Michele O'Brien
Doughkill
Carrig
Birr
Co. Tipperary
R42 AH31
14/06/2026

Re: Planning Application ABP-PAX 92.324279, Ballincor Wind Farm, Counties Offaly and Tipperary

BESS / Fire Risk Assessment

Substation & BESS Site Layout Plan

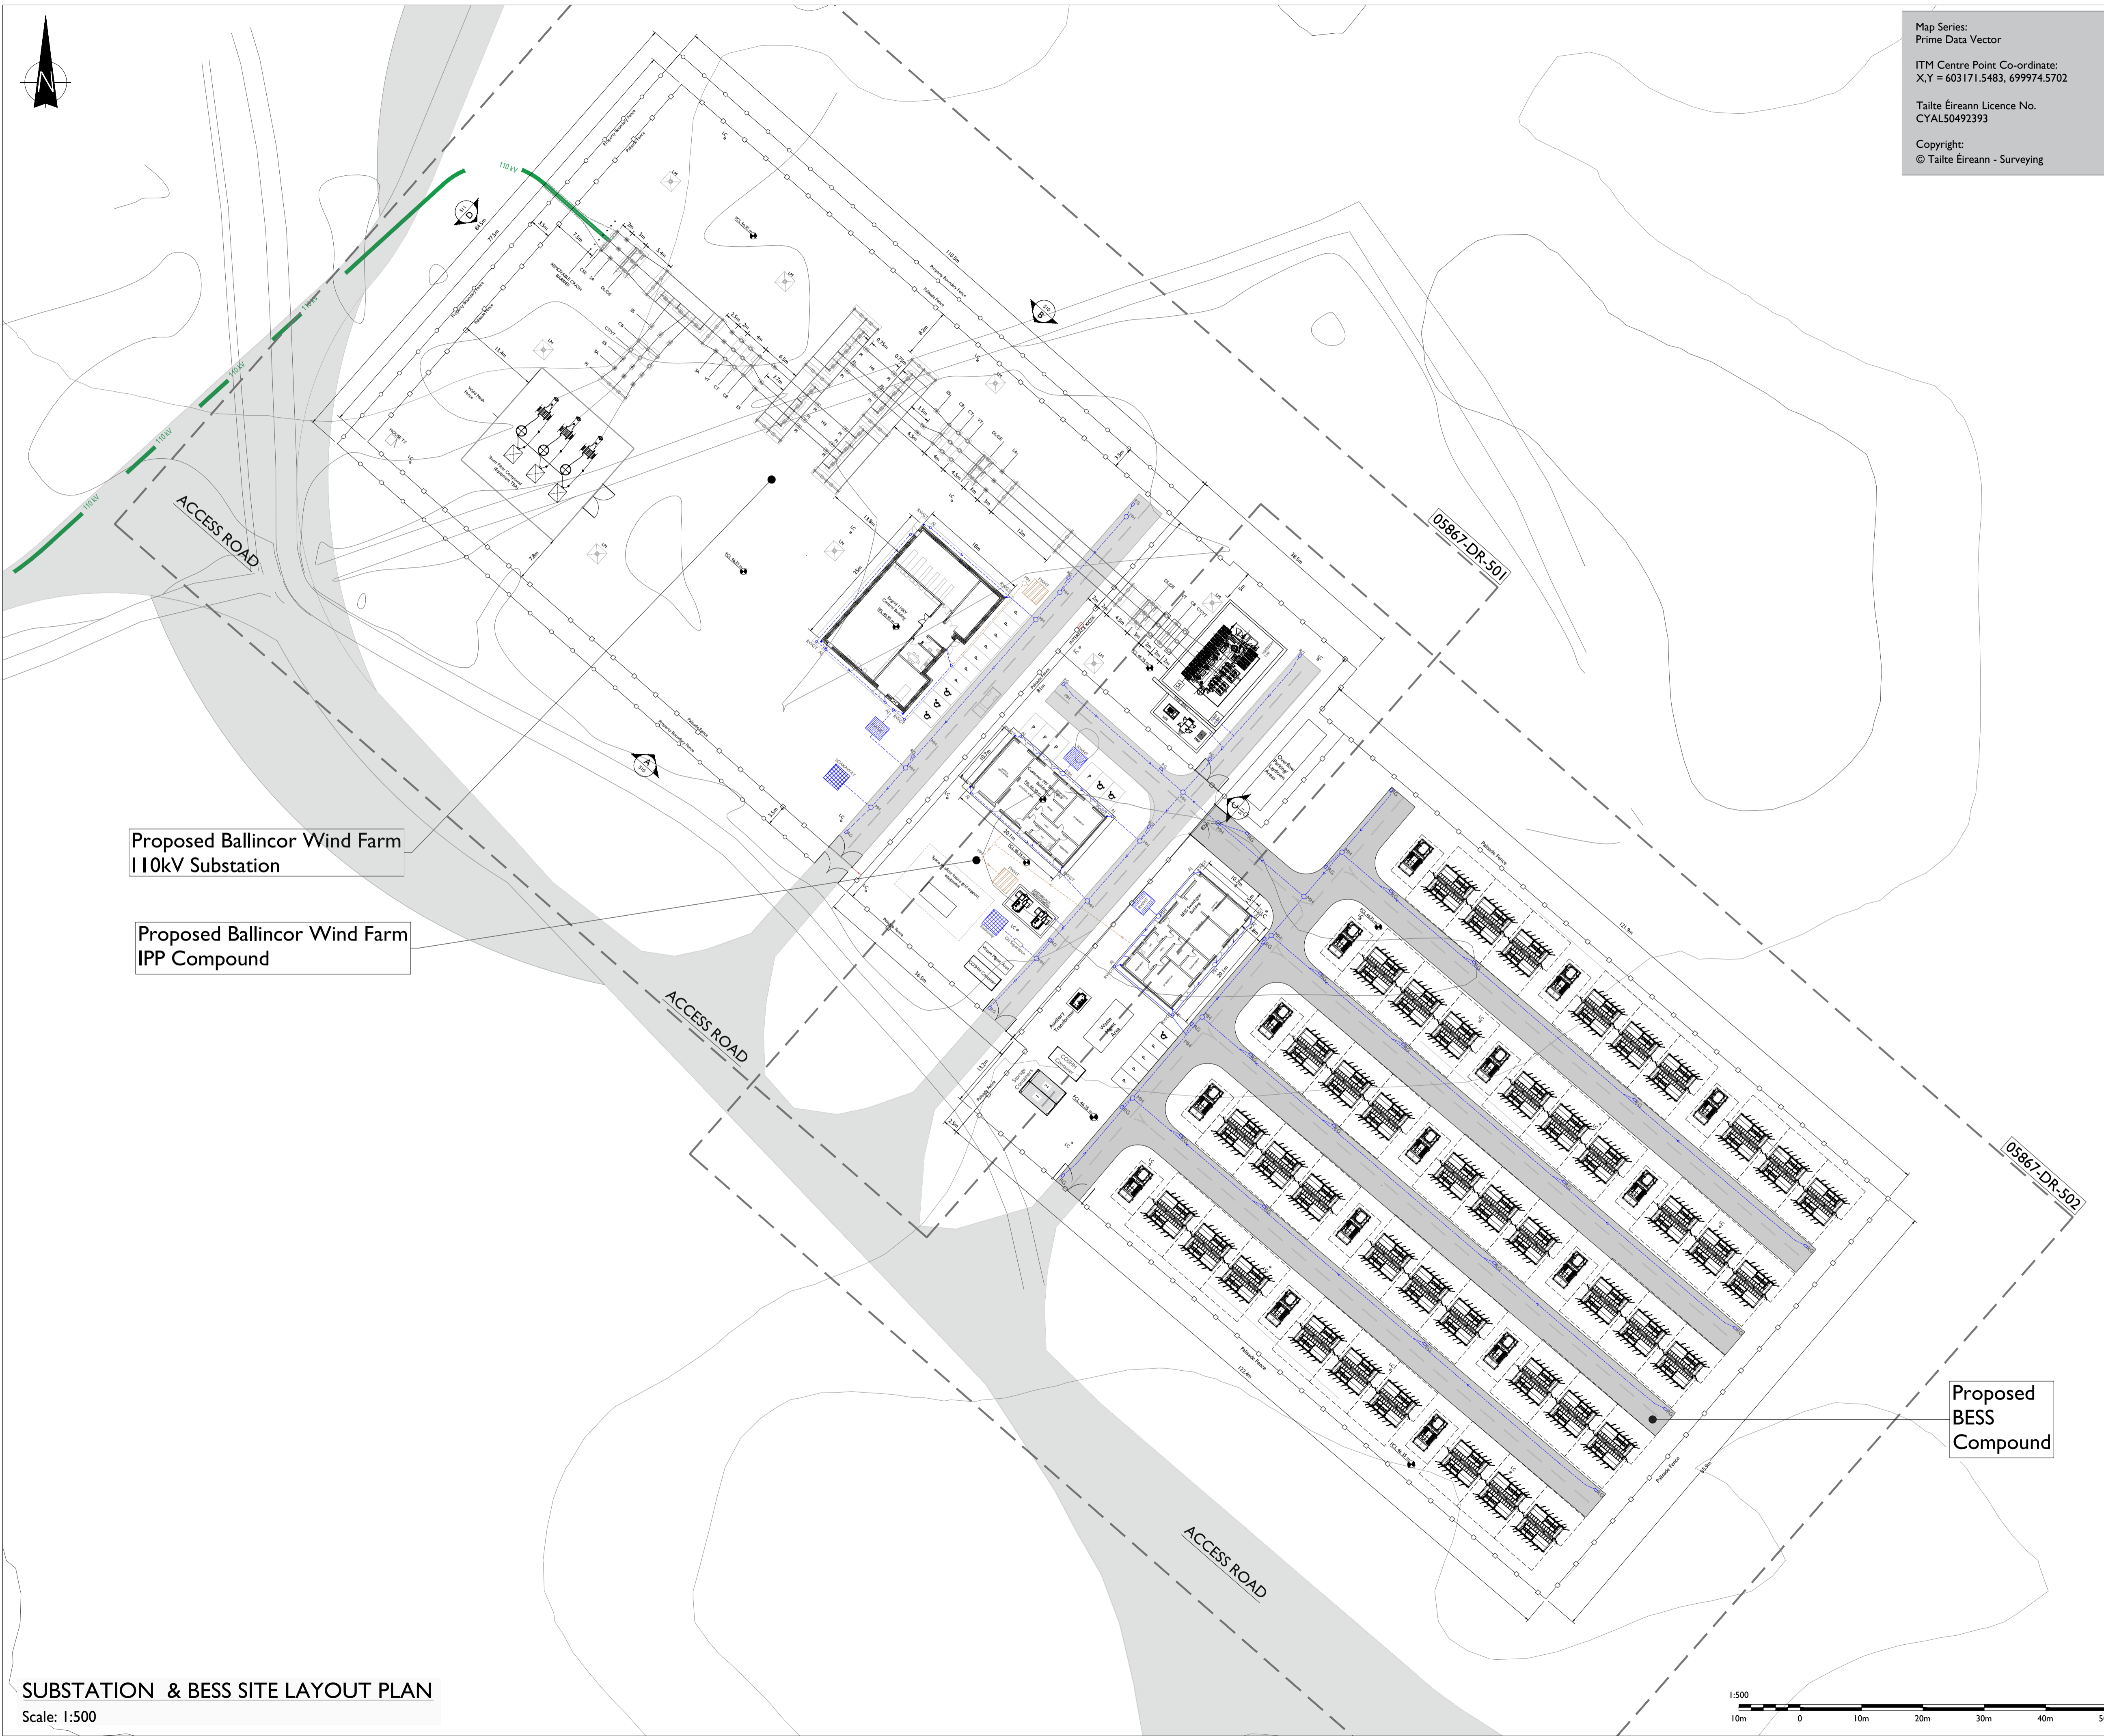
We will be living less than 1km from the proposed Battery Energy Storage System (BESS) facility comprising 90 lithium-ion battery containers on a 1.4-hectare industrial compound. The developer's own Fire Risk Assessment (Jensen Hughes, JG/1471/R1, March 2026) — prepared exclusively for and paid for by RWE — identifies that burning lithium-ion batteries produce toxic hydrogen fluoride gas, that fumes may cause dizziness or suffocation, and that the Novec 1230 suppression agent itself poses toxicity risks. Yet no dispersion modelling has been carried out, no assessment of how far these gases would travel towards my home, and no analysis of prevailing wind direction or impact on residential receptors.

The report concedes that an evacuation plan for surrounding residents "may be required" but provides none. It dismisses the risk to people in surrounding areas in two sentences, without stating the distance to the nearest home or considering what happens if someone is asleep when an incident occurs. The report acknowledges that its suppression systems may not prevent the most dangerous scenario: ongoing off-gassing and potential explosion after the initial fire is suppressed, because batteries continue to release flammable and explosive gases until they cool. The Pre-Incident Plan with the fire service has not been prepared. The waste disposal plan for toxic fire by-products has not been written. The Emergency Action Code signage has not been determined. The consultation with Tipperary Fire Service has not taken place, and the report itself acknowledges that firefighters may not be familiar with the specific techniques required for DC and lithium-ion battery fires. The report even contradicts itself on which suppression agent will be used — Novec 1230 on page 6, Sigma XT on page 27 — undermining any confidence in the specificity of the fire safety design.

The BESS containers are exempt from Building Regulations as structures "not frequented by people," meaning they are held to a lower fire safety standard than any occupied building — yet they will sit beside my occupied home. I am being asked to live next to an industrial-scale hazardous facility on the strength of a qualitative risk assessment containing no numerical probability analysis, no consequence modelling, and no completed emergency plans — only promises that these things will be done at some unspecified future date. As we live on a border between two counties, Offaly and Tipperary, our experience is that it can be extremely difficult to get emergency services as they seem to never know which jurisdiction we fall into. This can result in time wasted as we get passed back and forward and raises additional concern for us in the absence of a completed emergency plan. This is not acceptable. An Coimisiún Pleanála cannot grant permission on the basis of plans that do not yet exist.
